## **Review of Stage 1 Safety Audit and Designers Response.**

### **DOMUSEA DEVELOPMENTS PROPOSED RESIDENTIAL DEVELOPMENT THE BOWERIES, BARNHAM ROAD, EASTERGATE STAGE 1 - ROAD SAFETY AUDIT OCTOBER 2019**

Review of stage 1 safety audit carried out by Martyn Parr, Mayer Brown during October 2019, and designer's response.

scale 1:250 @ A3 date OCTOBER 2019 drawing number MBSK191001-01	title VISIBILITY SPLAYS AT ACCESS	client DOMUSEA DEVELOPMENTS project THE BOWERIES, BARNHAM ROAD EASTERGATE	drawn by JME checked by AP cad file FIGURES A.DWG rev. D
---	-----------------------------------	---	---

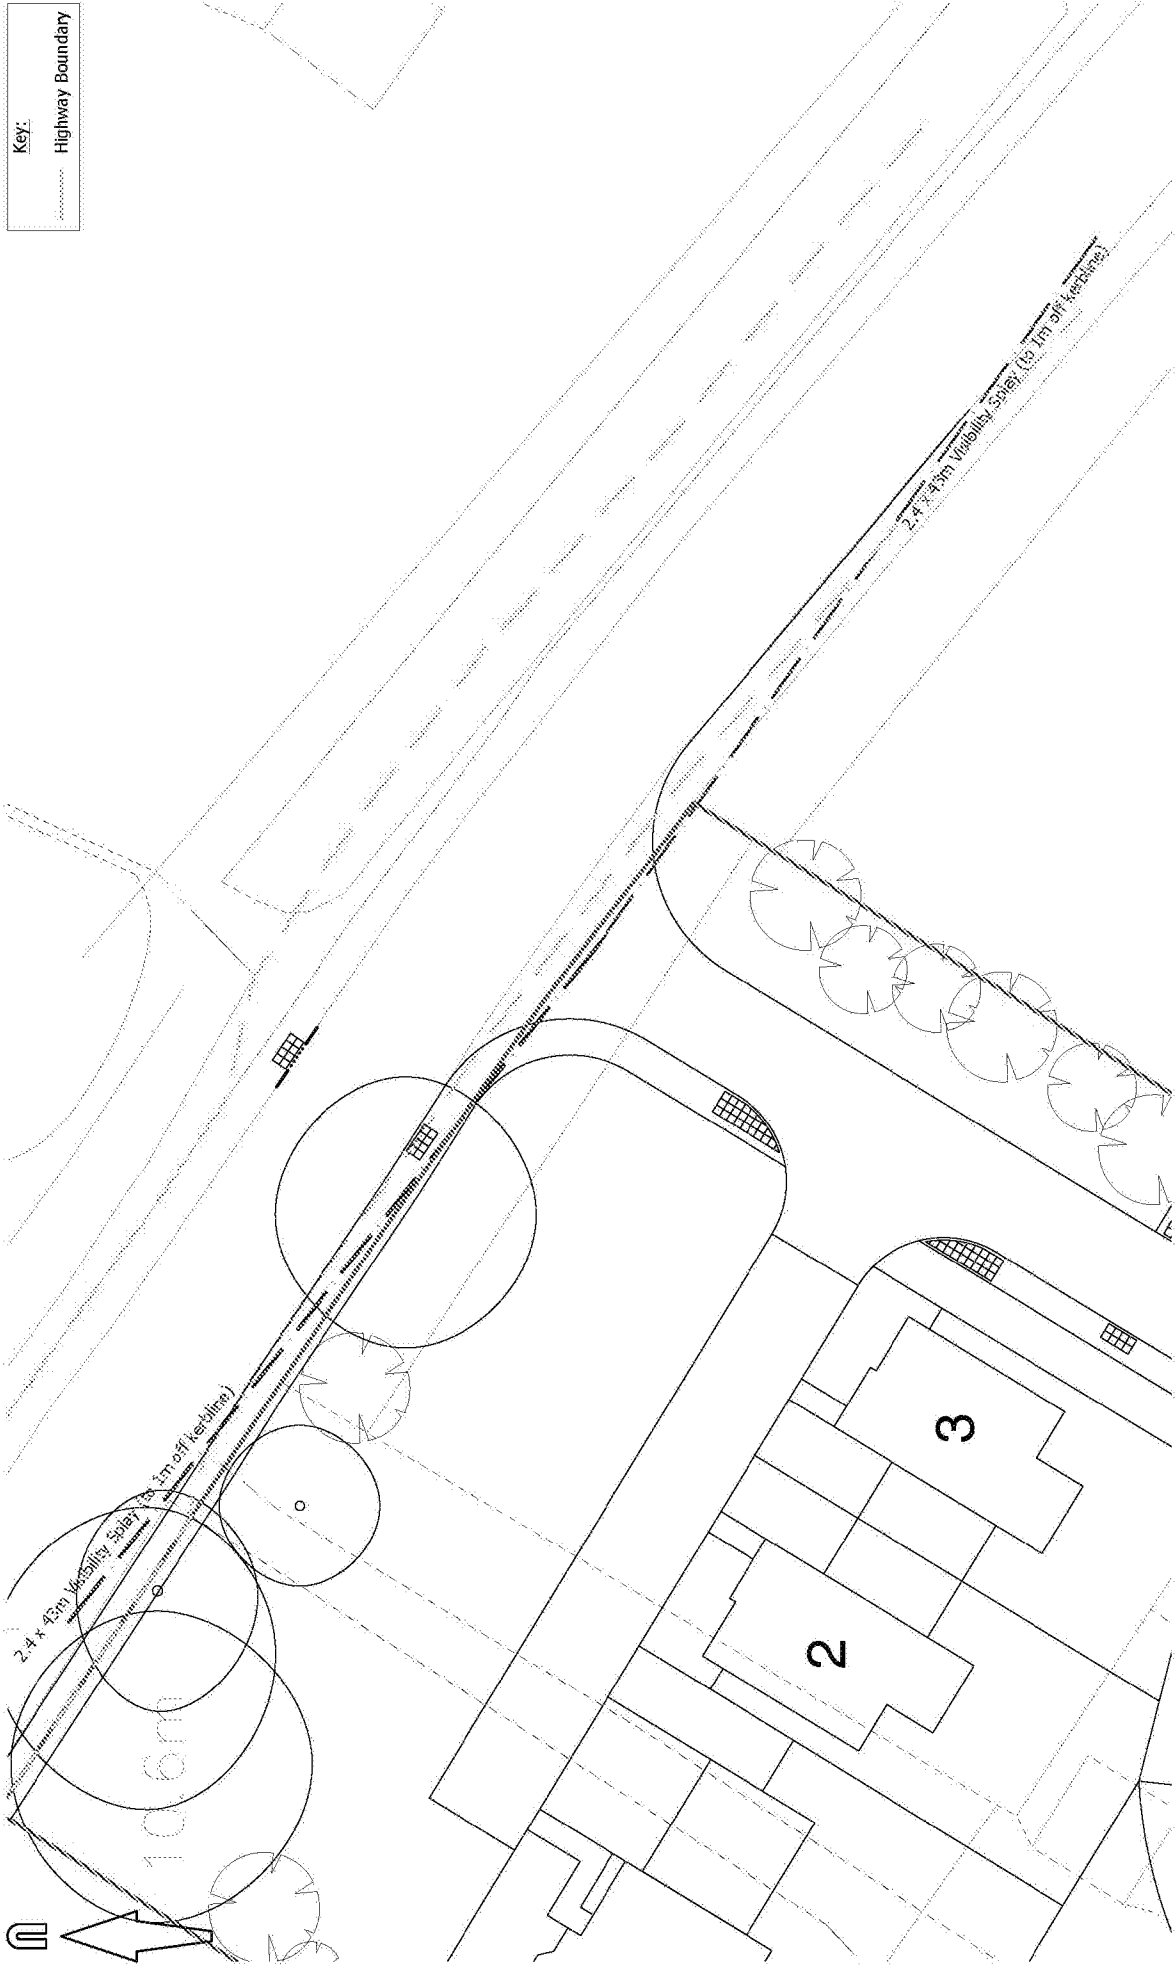
Agree with auditor, this matter can be addressed by way of planning condition.
